# Gatwick Airport Northern Runway Project

## Appendix E: Response to SCC's Airfield Drainage Queries

Application Document Ref: 10.24

PINS Reference Number: TR020005

Figure 5.1.1 Proposed relocation of Pond A

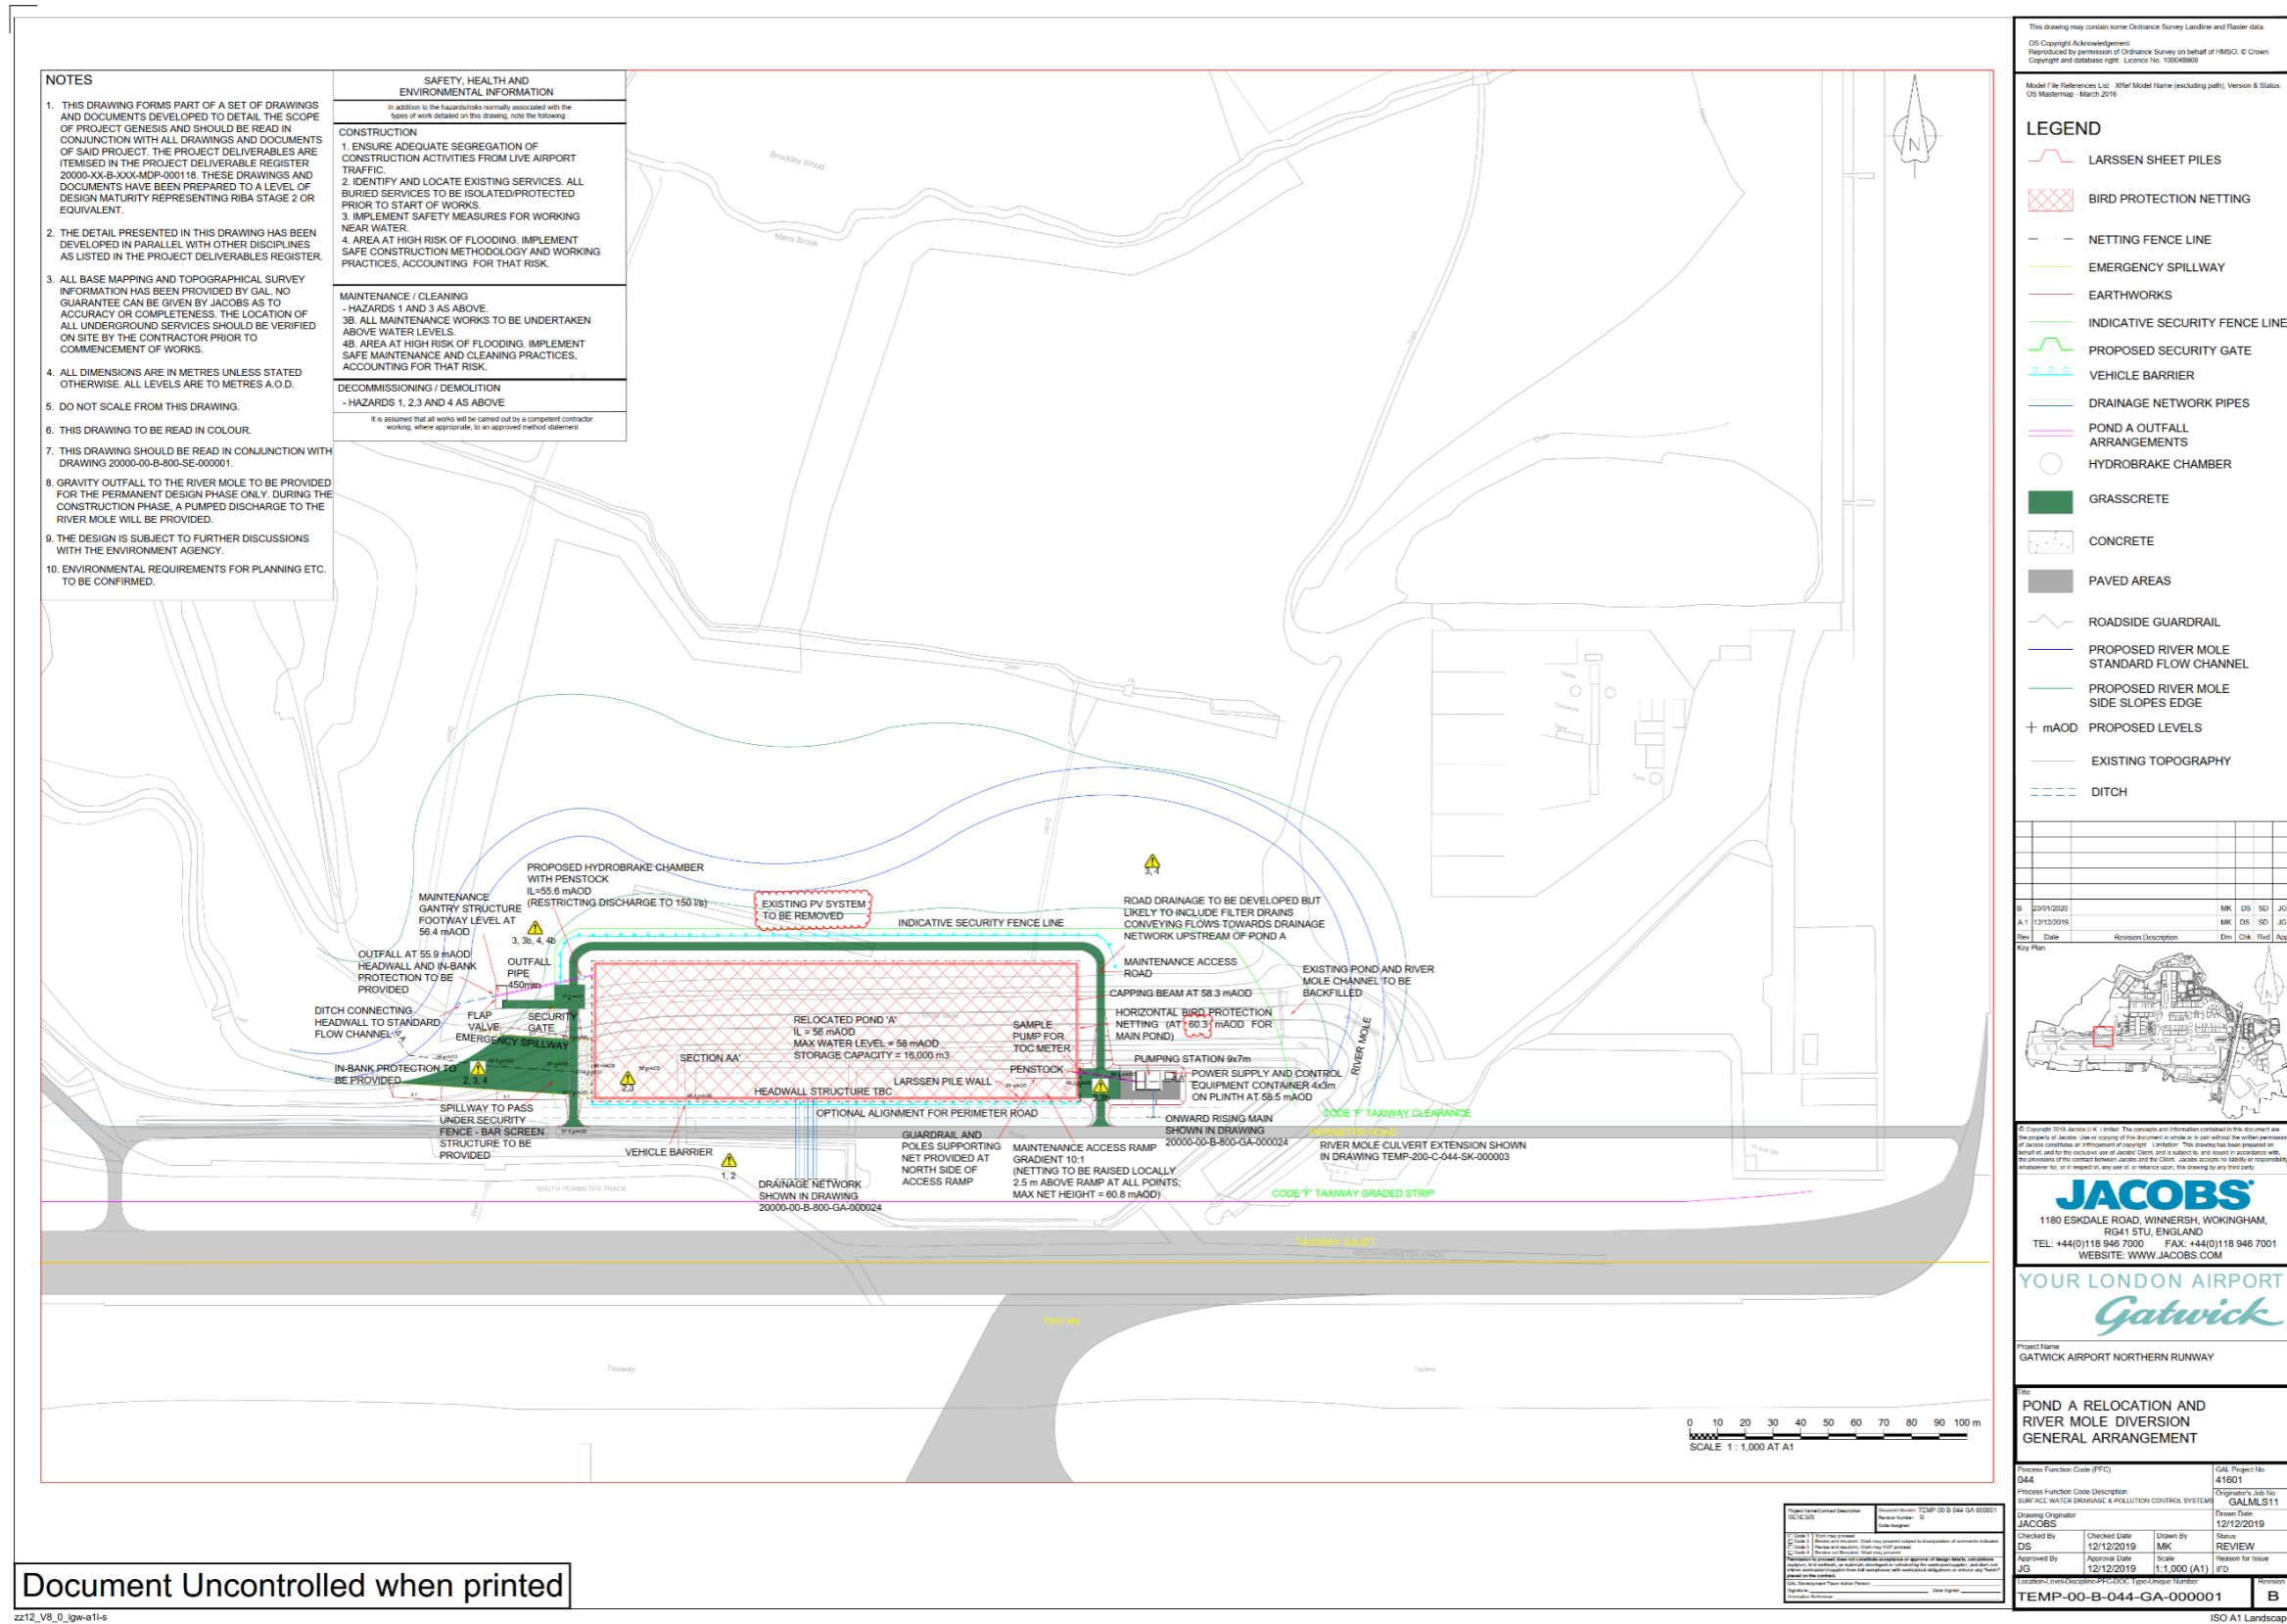
<p>The relocation of Taxiway Juliet will necessitate the removal of Pond A that drains the western end of the airfield. A new surface water pumping station will be constructed to receive the flows that currently drain to Pond A, which will pump them into the Pond M catchment.</p> <p>These impacts have been considered in <b>ES Appendix 11.9.6 Flood Risk Assessment</b> <a href="#">[AS-078]</a>.</p>
8	<p>Is the intention to replicate the current drainage construction layout/specification for the re-positioned runway or adopt a different approach? i.e. can GAL confirm if drainage will be replicated in the same position (between the new Northern shoulder and the runway) or if not how surface water would drain from the re-positioned runway? Further details of this approach should be provided</p>	<p>The drainage of the repositioned Northern Runway will follow the same design philosophy as the existing, its configuration and alignment will be finalised through detailed design.</p> <p>The repositioning of the Northern Runway will necessitate repositioning of its associated drainage, but only to the extent to drain the runway and connect it into the existing drainage system slightly further north than at present.</p> <p>Further details on the existing and proposed drainage approach for northern runway are included in sketches GALNRP-SK003, GALNRP-SK004 and GALNRP-SK001 in <b>Annex A</b>.</p>
